Rezoning Transportation Analysis

Petition Number: 2020-105

Date	Description
08-19-20	First Review
09-22-20	Second Review

RZ-1.0

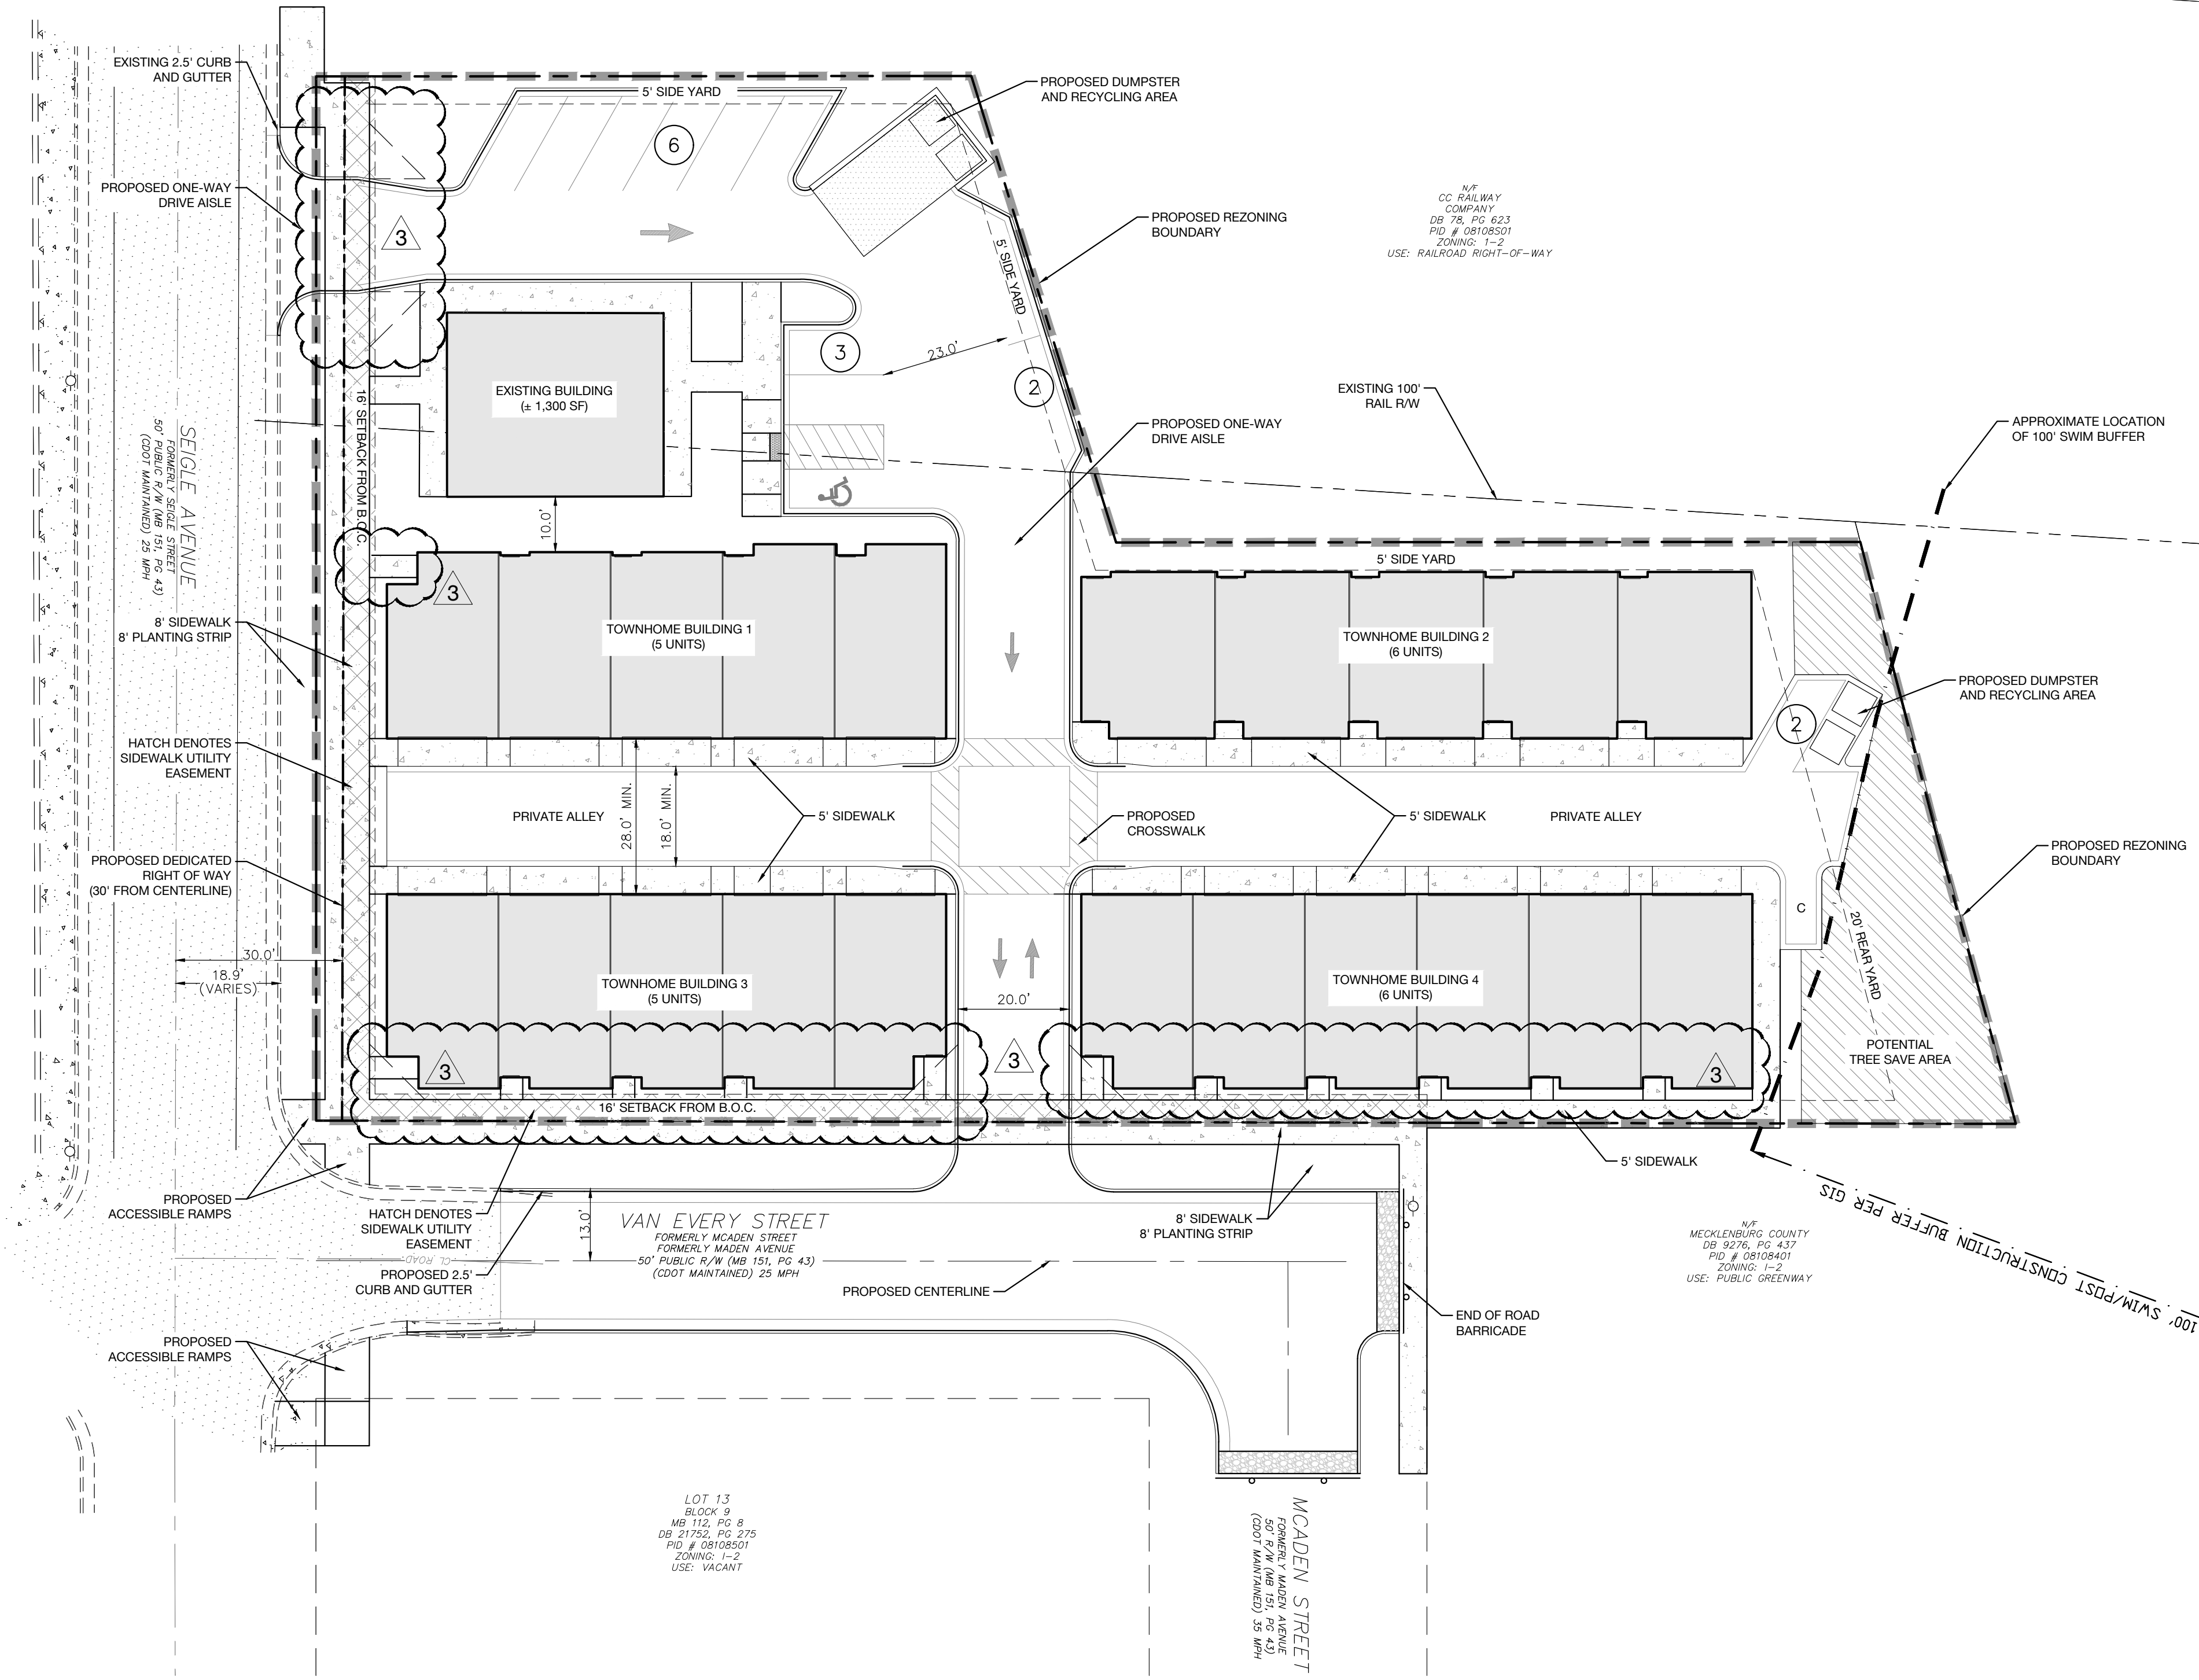
The site is located on a minor thoroughfare and a local road. The petitioner commits to constructing an 8-foot planting strip and an 8-foot sidewalk along Seigle Avenue and Van Every Street in accordance with the Charlotte WALKS Plan. The site plan needs updated to label and dedicate the 30' right-of-way from the road centerline along Seigle Avenue.

The site plan should label the 30' right-of-way from the road centerline along Seigle Avenue.

- 5. The petitioner should revise the site plan and conditional note(s) to reconstruct two curb ramps on the north quadrant of the Seigle Avenue/Van Every Street Intersection in accordance with PROWAG and the ADA law.
